July 27, 2023

Re: SP23-003, "Hidden Valley PRD", Technical Review 1
Location: 12527 51st Ave NE

RE: Hidden Valley Short Plat, File# SP23-003
5 lot preliminary short plat/PRD on 1.24 acres
12527 51st Ave NE & Parcel # 30050300302600

**FRONTAGE
PLAN &
PROFILE**

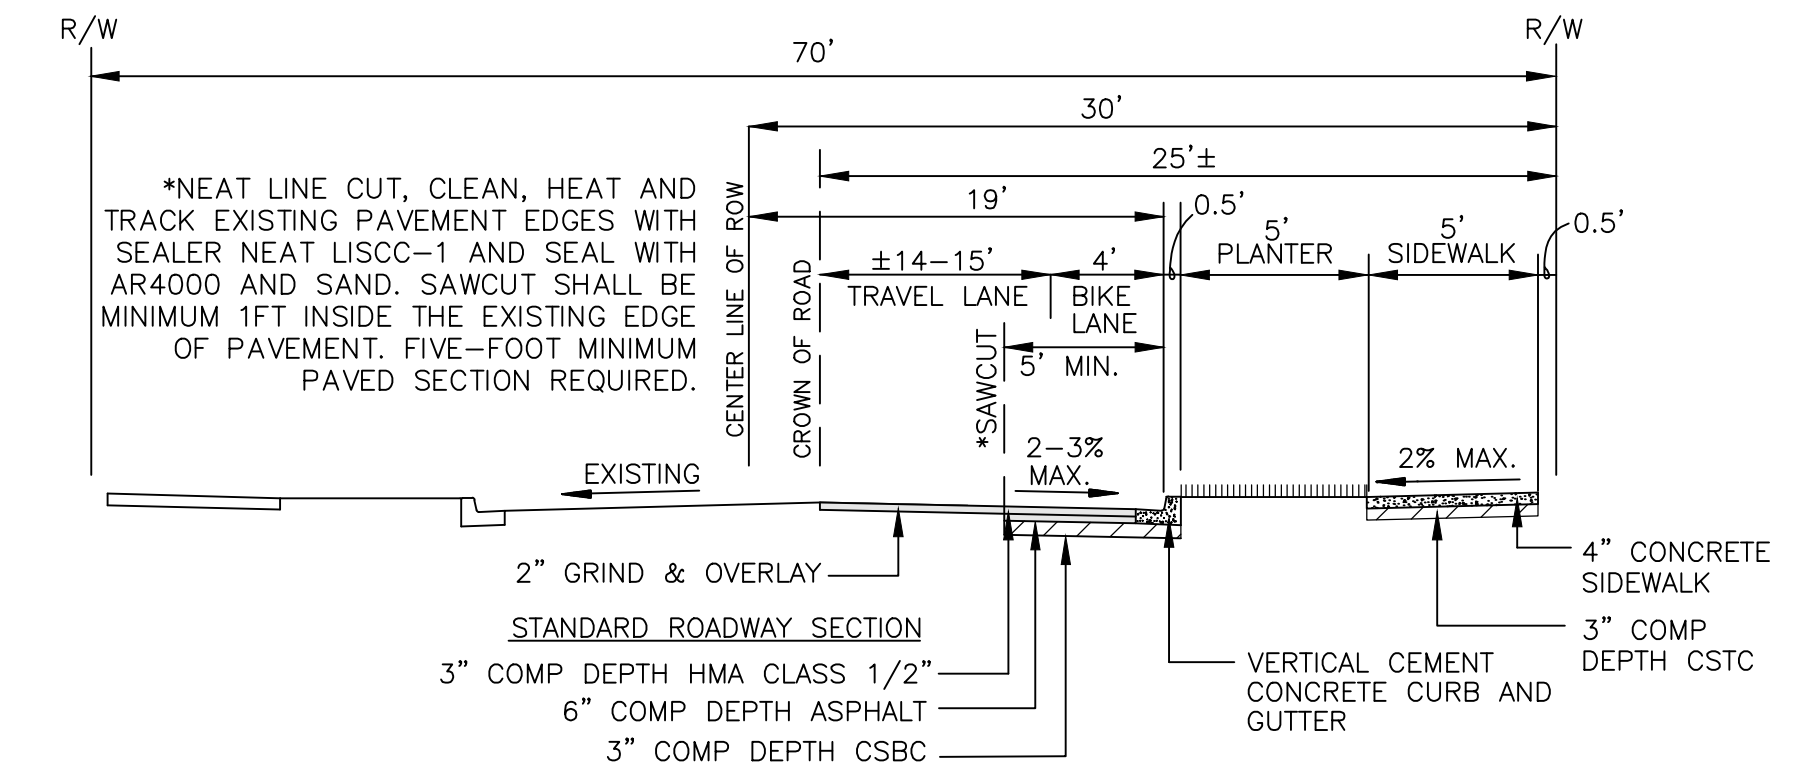
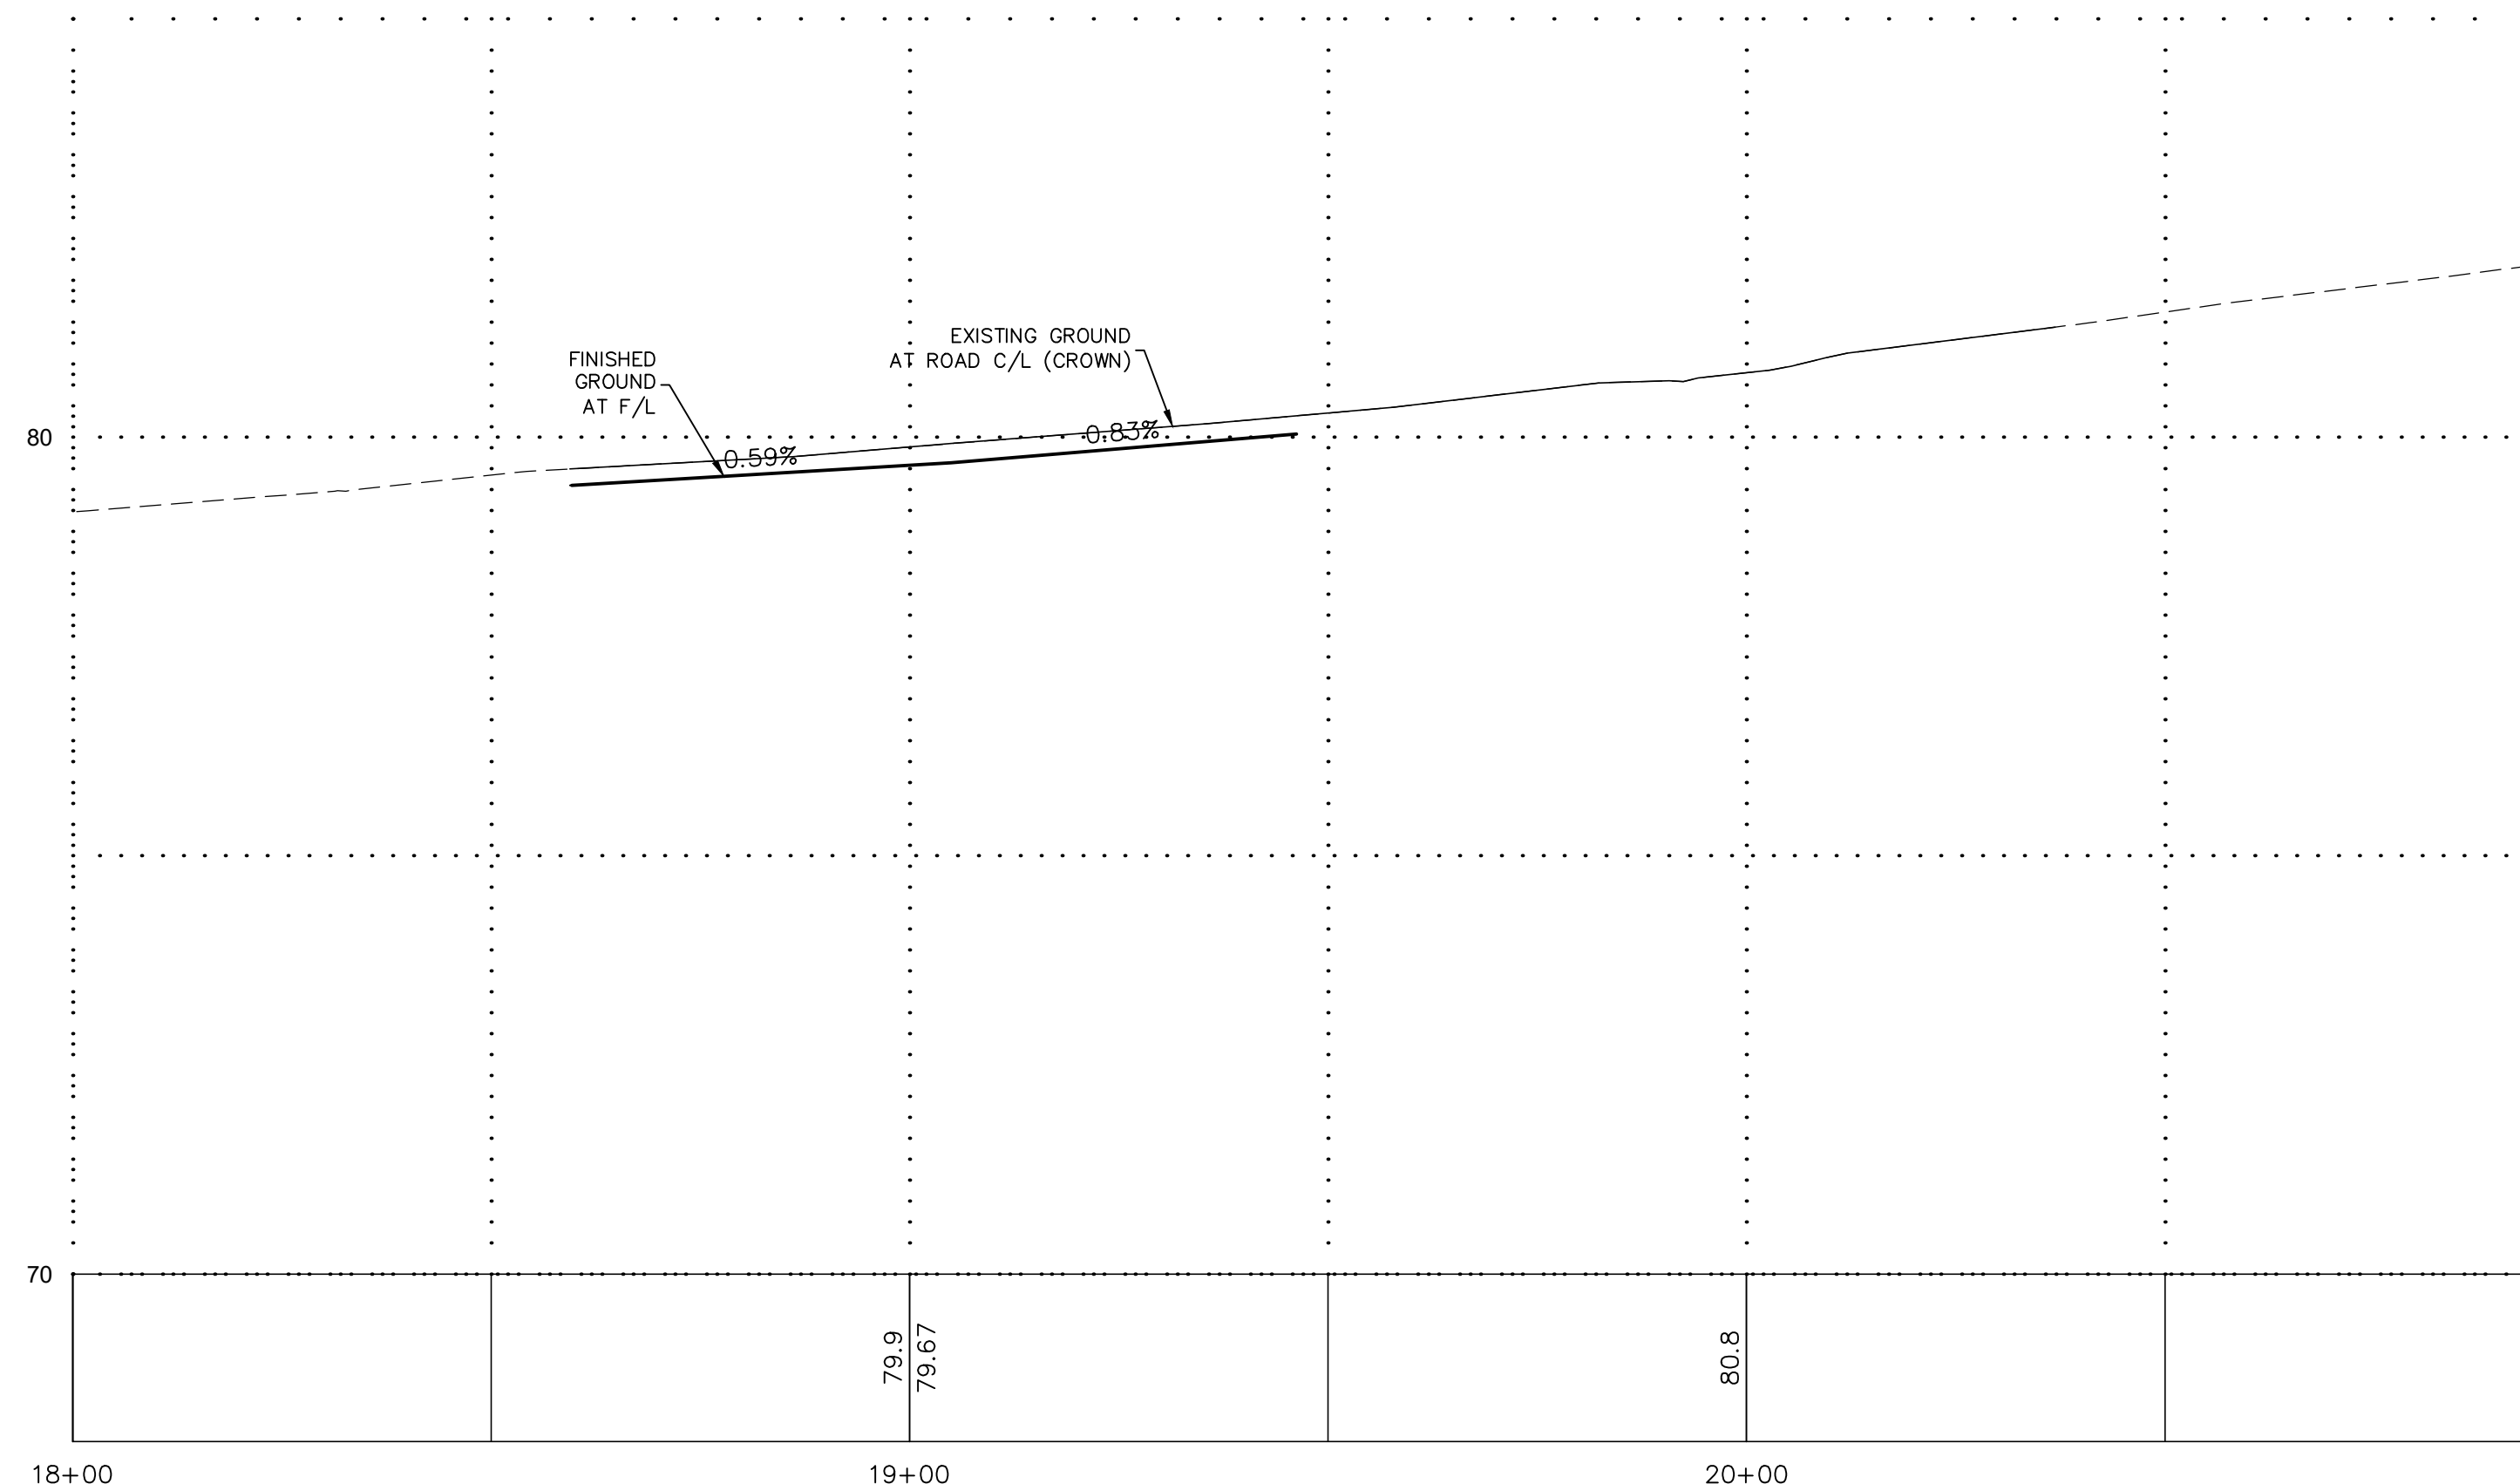
- a. 51st Ave NE is classified as a minor arterial and is to be built with 2 travel lanes, a turn lane and bike lanes, together with curb, gutter and a 5’ sidewalk with a 5’ planter. Reference SP3-201-004 of the EDDS.

- 4) 51st Ave NE frontage:
 - a. Designated as Minor Arterial roadway with 43' of asphalt pavement including three lanes, 5' bike lanes, curb, gutter, landscape strip, 5' sidewalks and PUD Street lighting per EDDS Standard Plan 3-201-004.

- i. Site specific roadway cross-section shall provide dimensioning of full roadway width including all proposed designated lanes upon roadway.
 - b. ADA curb ramps shall be required upon east side of 51st Ave NE for unmarked crosswalk(s) at intersection of 51st Ave NE & 126th ST NE.

SECTION B-B
126TH ST NE
LOCAL ACCESS STREET
DESIGN SPEED = 25 MPH
NOT TO SCALE

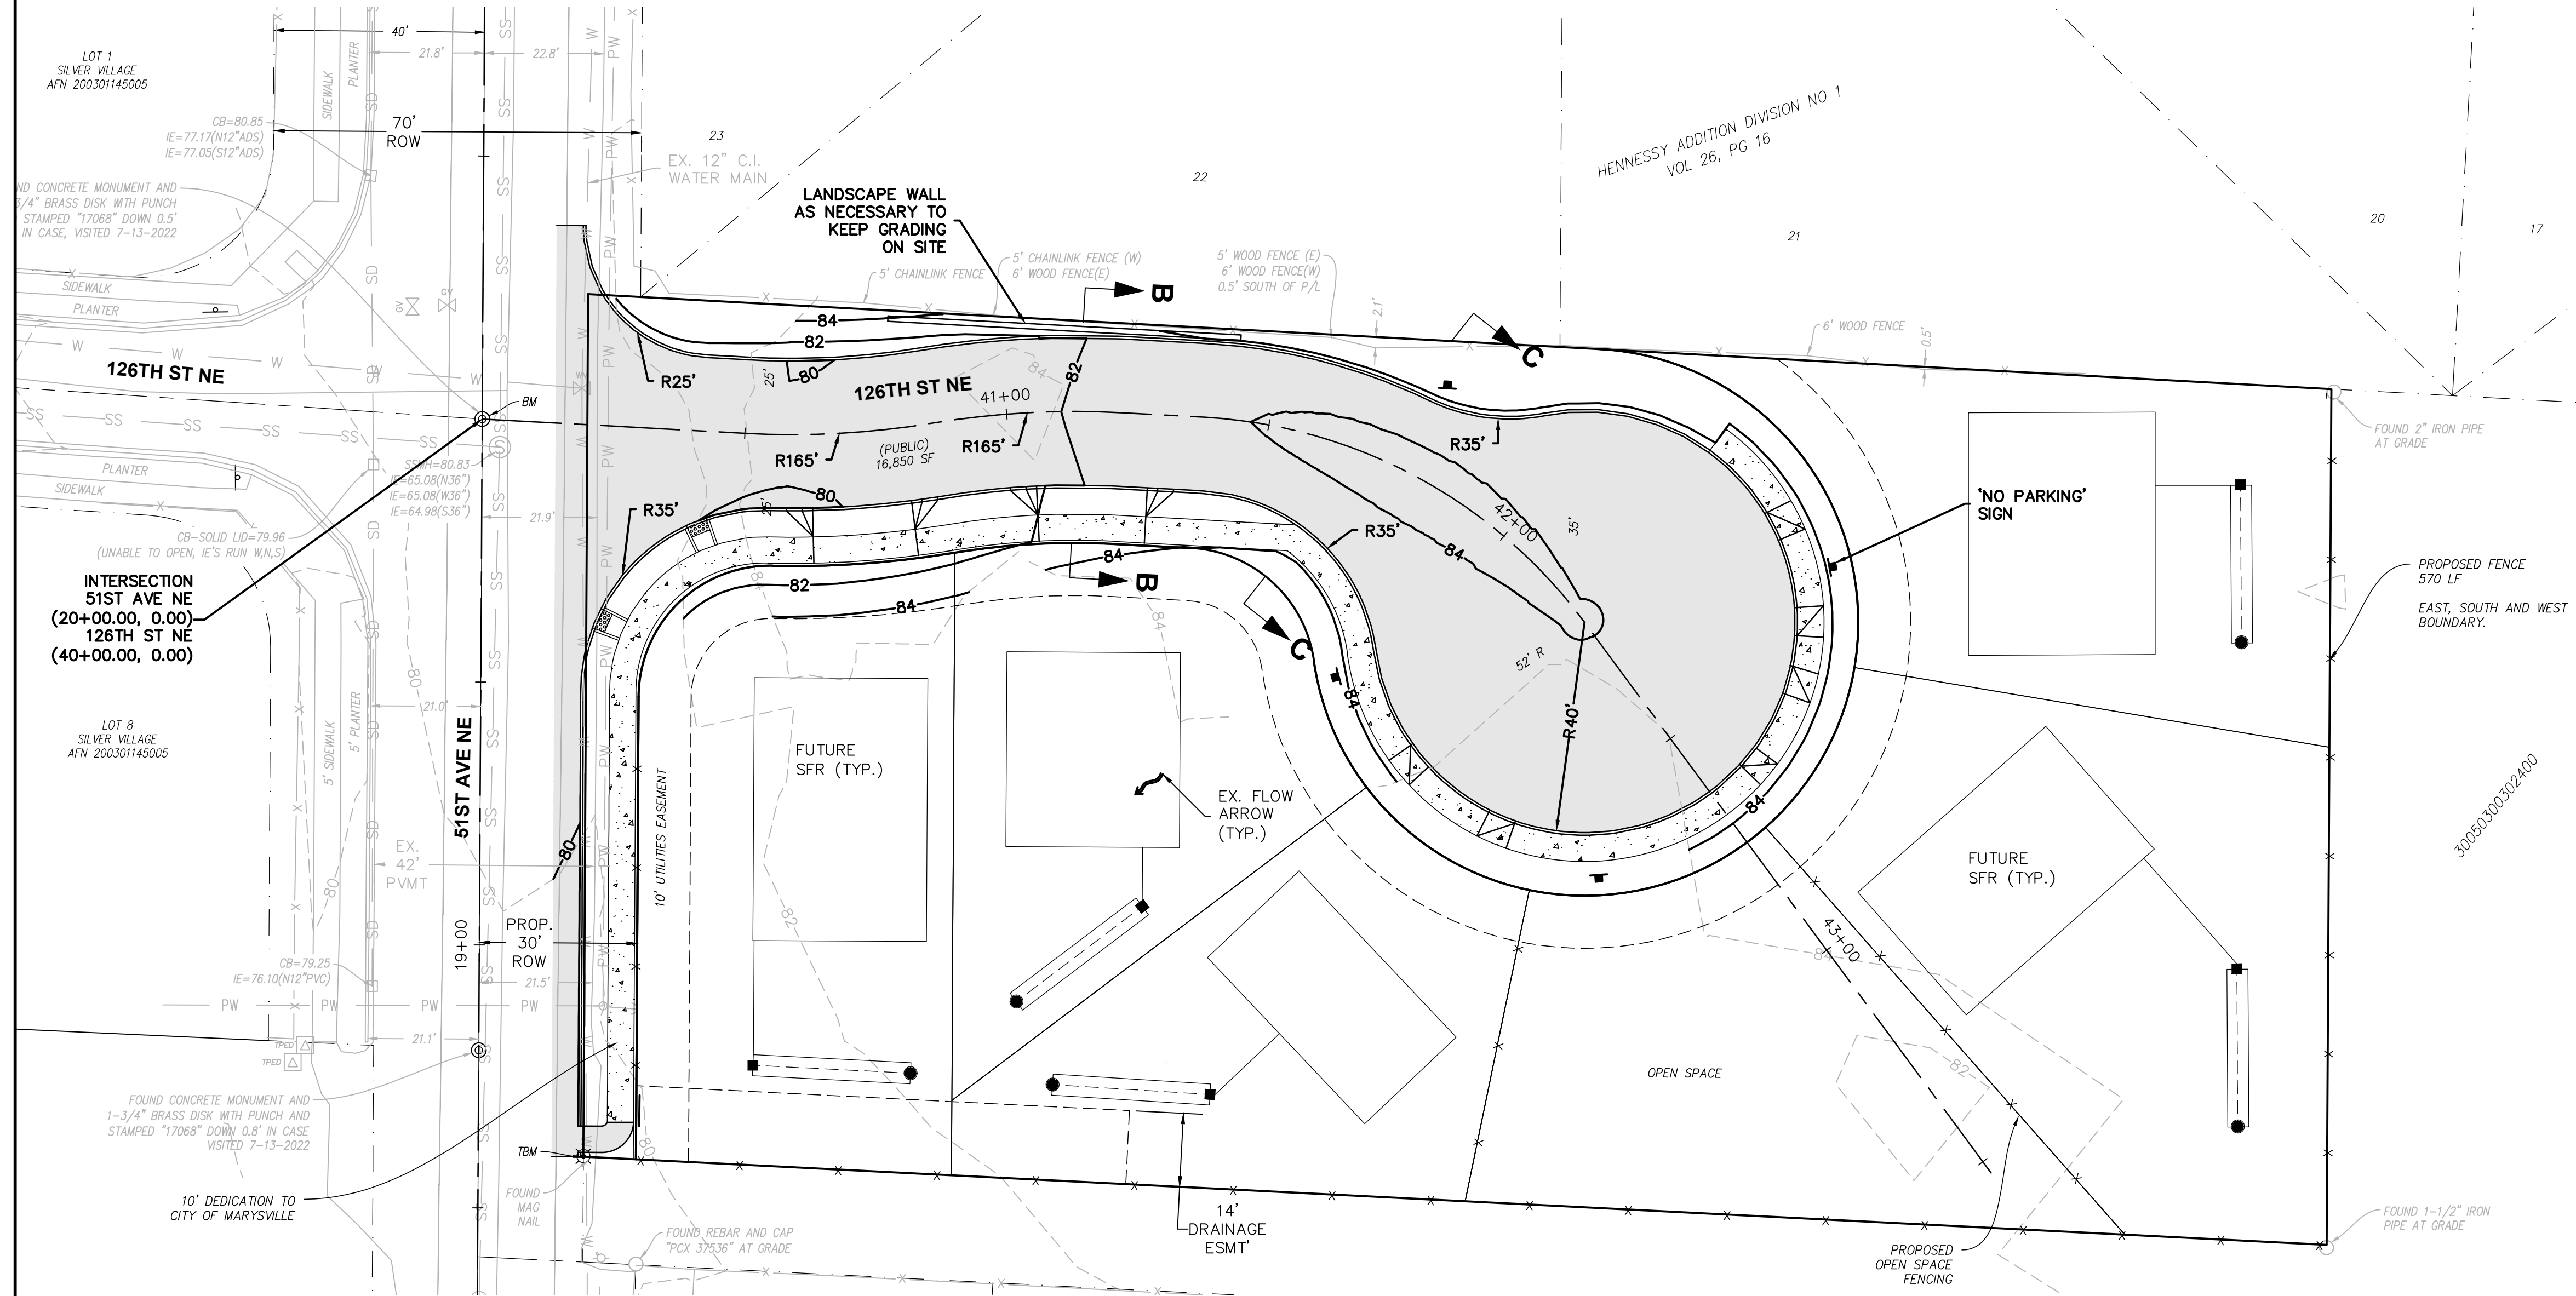
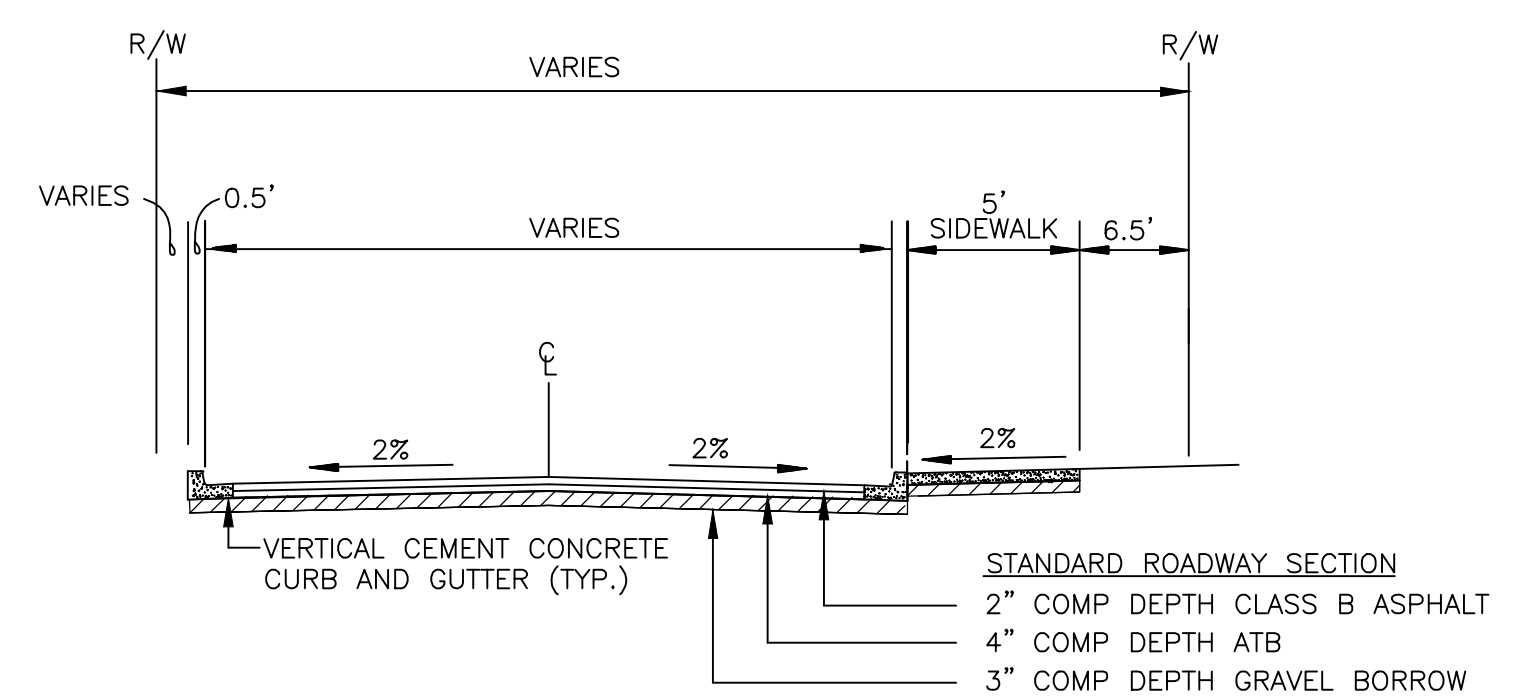
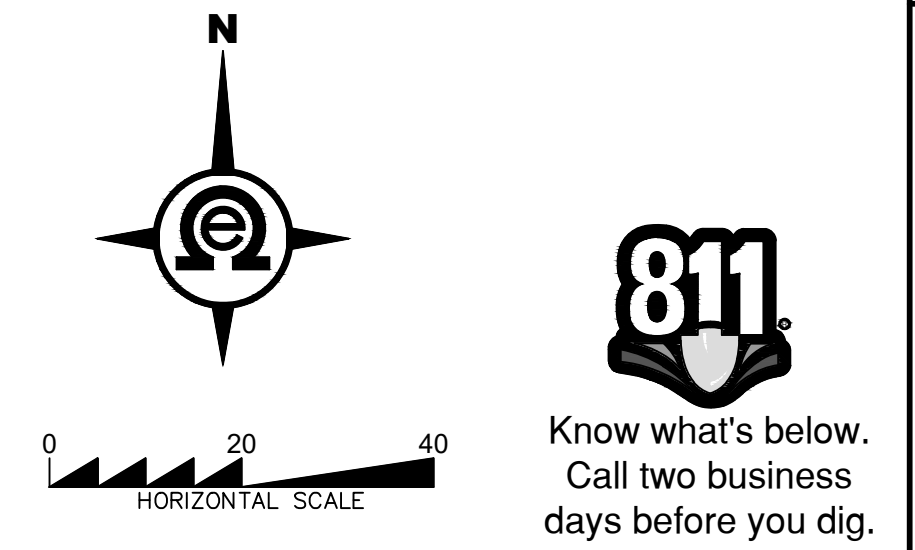
5. **Access:**
 - a. The new roads shall be constructed in accordance with SP 3-202-002 of the EDDS. You have proposed something that does not meet the City standard. In order to consider something other than the standard, an engineering variance will be required with justification.
 - b. The minimum width of a residential driveway is 12-feet and the maximum is 26-feet. Curb cuts shall be limited to a 20 foot maximum.
